Sheringham Shoal and Dudgeon Offshore Wind Farm Extension Projects

Marine Processes Technical Note

Document Reference: 13.5

1 Response to Natural England Comments

Figure 6.11 Zone of Potential Influence on the Tidal Regime

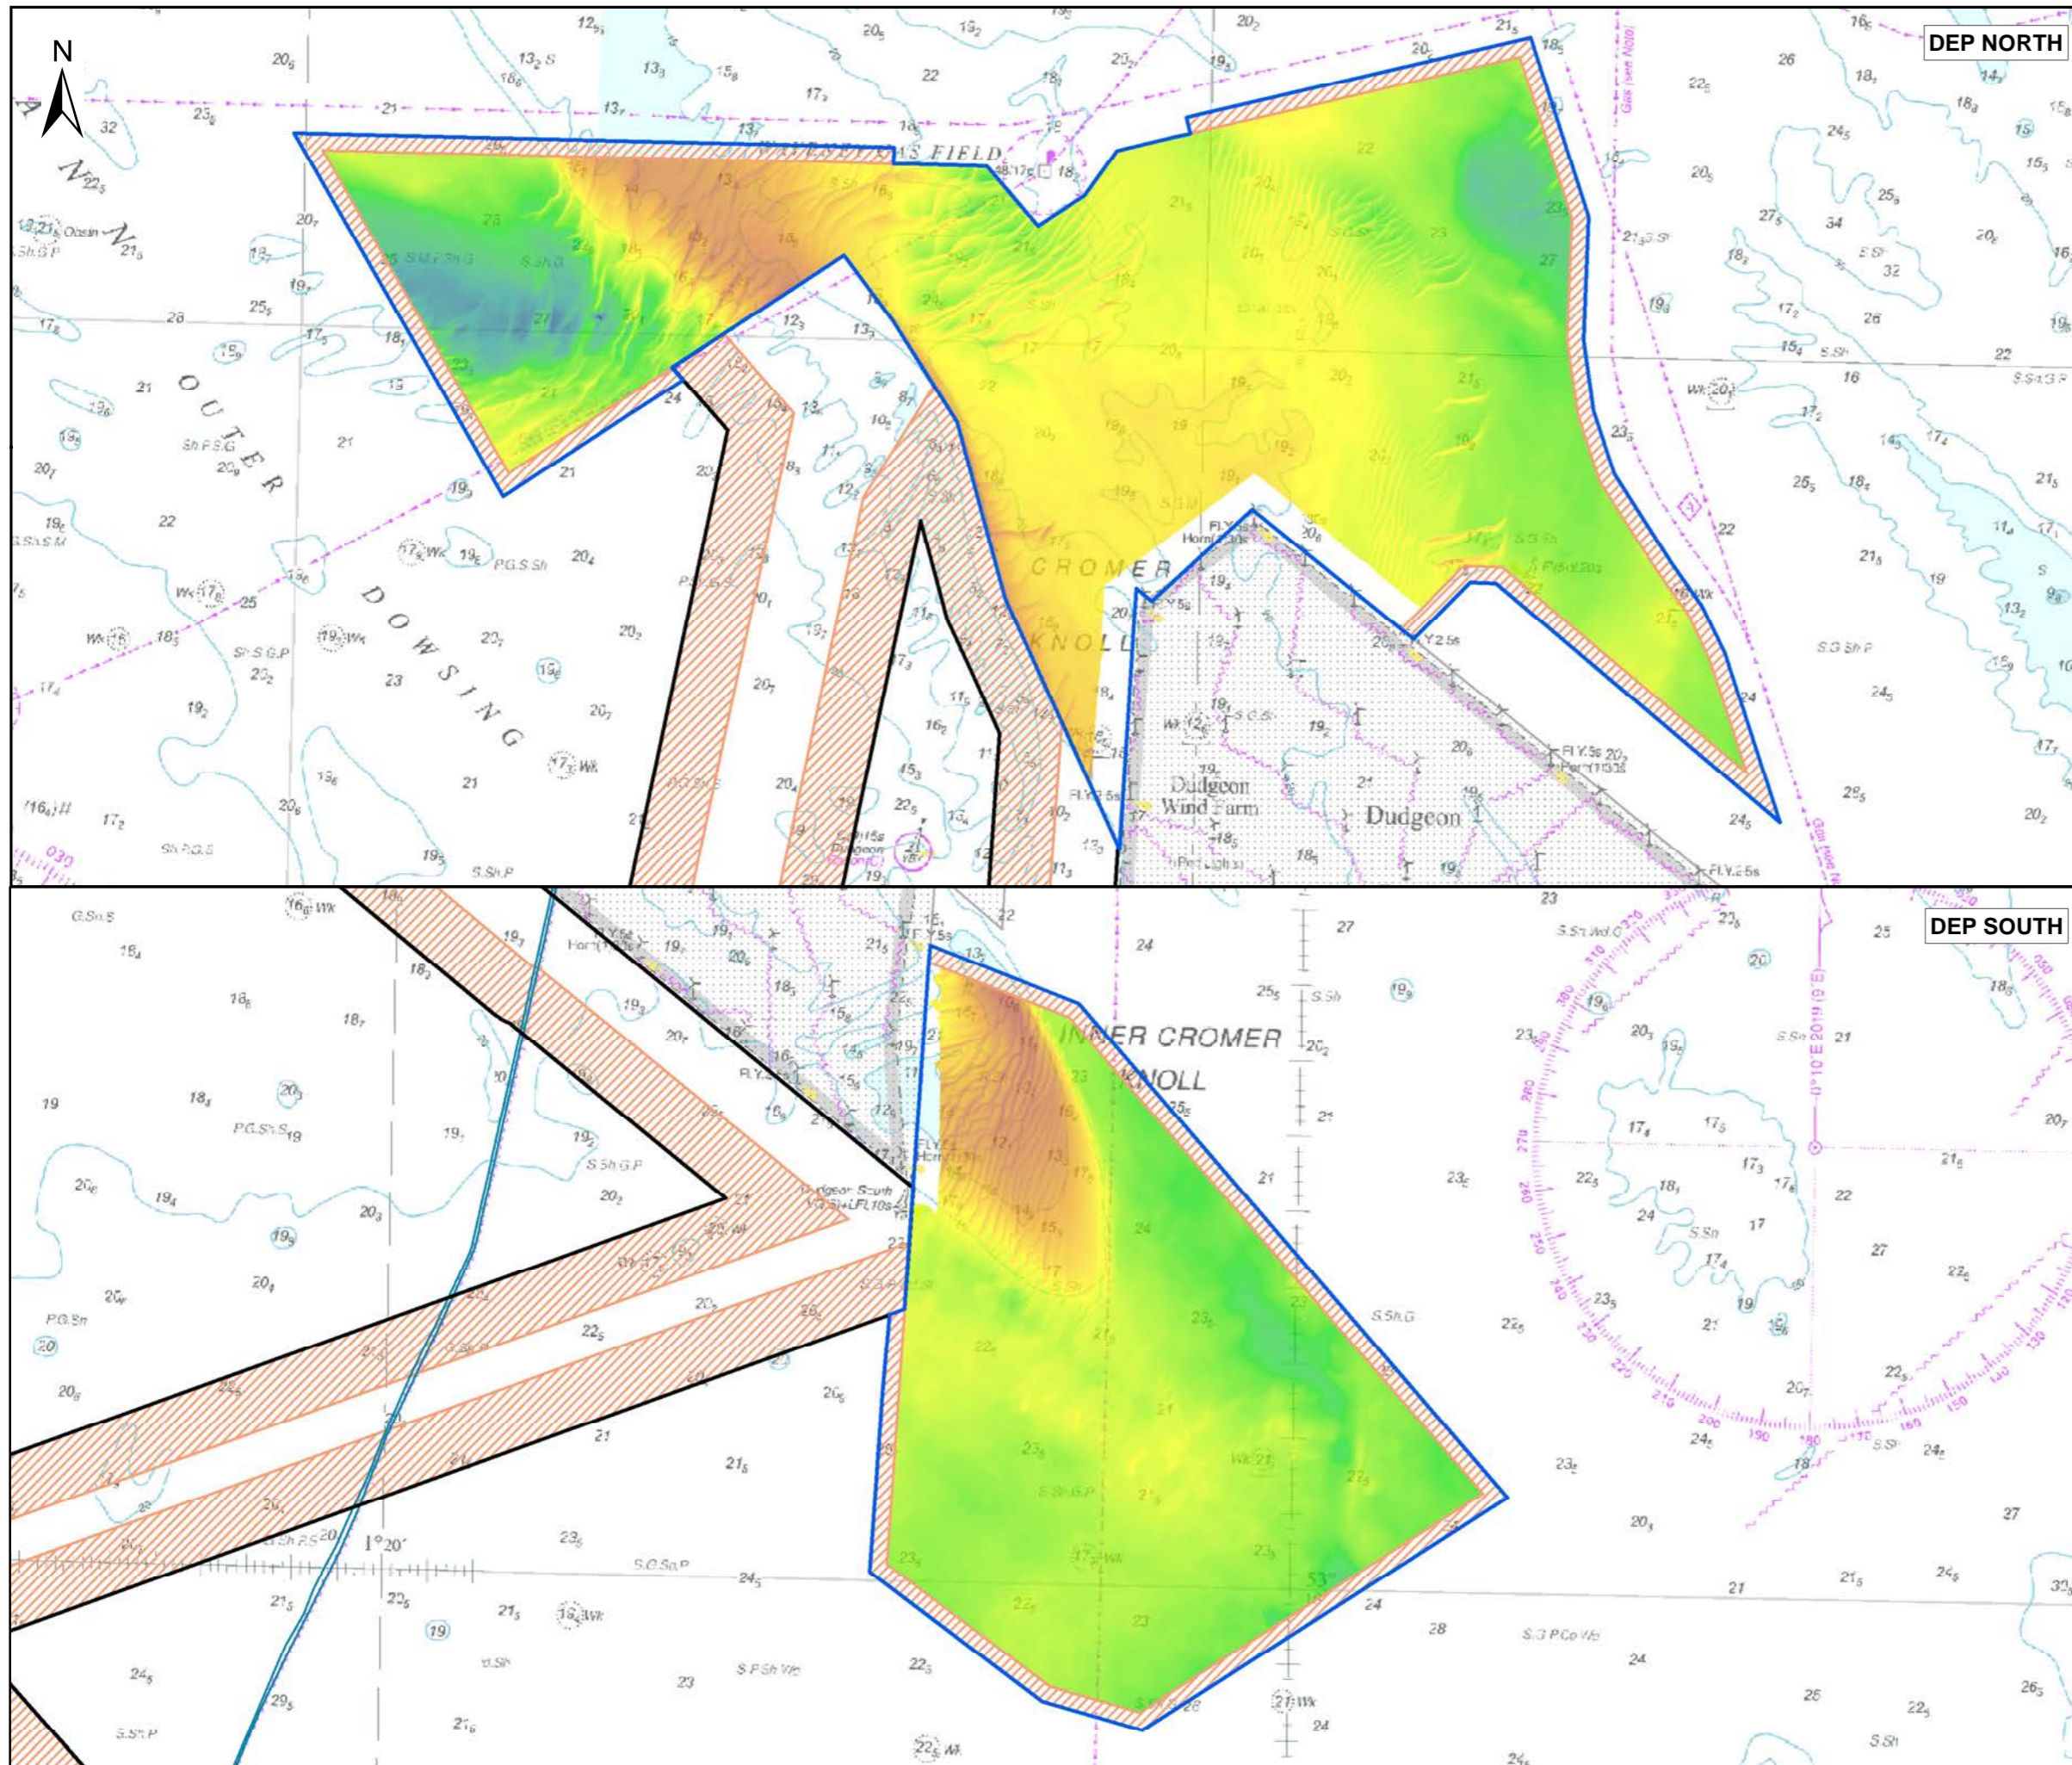
23. ID 47: *Point 316. The maximum zone of potential influence (ZoPI) on the tidal regime is presented in Figure 6.11, which we welcome. However, marine protected areas have not been identified on this map. It would be useful to identify marine protected areas on Figure 6.11 to show where they overlap with the ZoPI.*

24. The updated Figure 6.11 is provided as **Figure 10** below. With respect to the overlap shown with the Inner Dowsing, Race Bank and North Ridge Special Area of Conservation (SAC), the potential increased suspended sediment concentrations (SSC) and deposition effects during construction, operation and decommissioning; and changes to physical processes resulting in changes to sediment supply (i.e. sediment transport effects) during operation (but in relation to the SEP wind farm site only), are assessed within the **Report to Inform appropriate Assessment (RIAA)** [APP-059].
